Subject: AB/36/12/DOC New Heritage Centre Mill Road, Arundel - protection of the scheduled monument (Blackfriars)

Subject: AB/36/12/DOC and AB/47/12/DOC Arundel Museum

From: Anita Gardner
Sent: 16 April 2012 11:58
To: Ian Brewster
Cc: [REDACTED]
Subject: AB/47/12/DOC -Archaeological and Tree Protection works - New Heritage Centre, Land off Mill Road, Arundel

Arundel Museum – Site set up plan

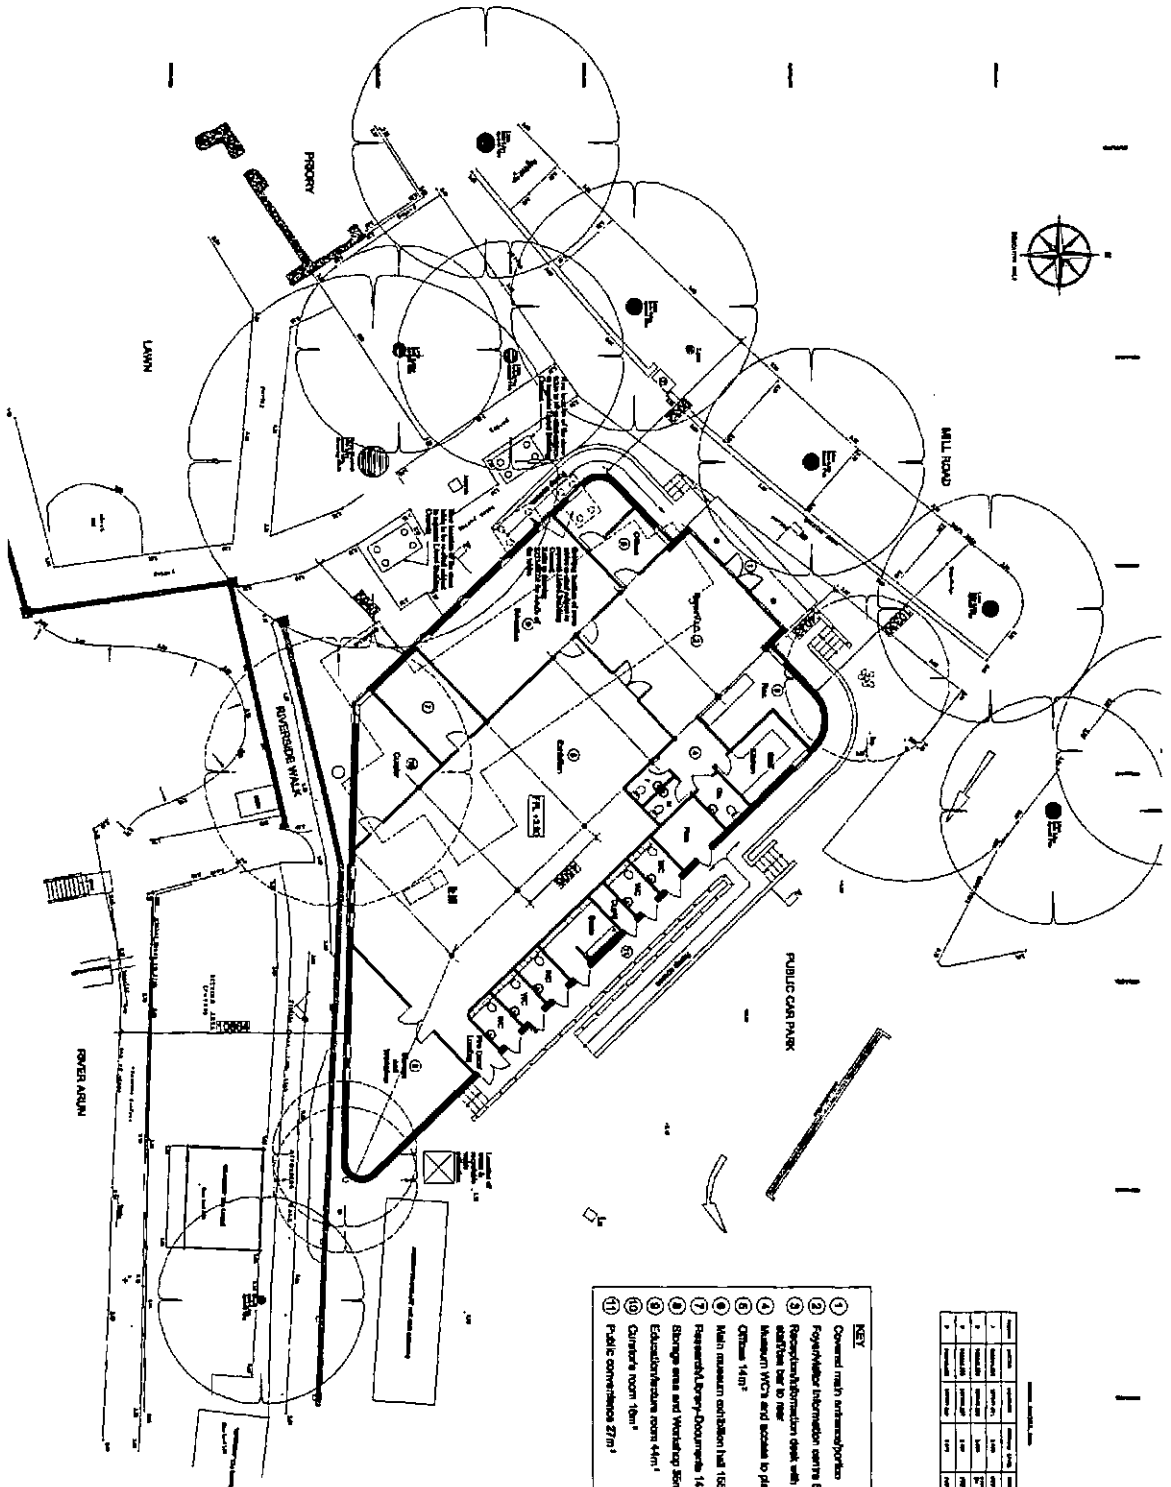
Dear Anita, further to our telephone conversation earlier today I can confirm that I am happy with the method proposed under condition 9 for the protection of the scheduled ancient monument, namely that all access to the construction site and compound will be from the Mill Road car park entrance on the eastern side of the 'footprint' of the new building. Given adequate Heras fencing and the presence of the TPO mature chestnut tree there should be no foreseeable issues. Yours sincerely, Mark Taylor
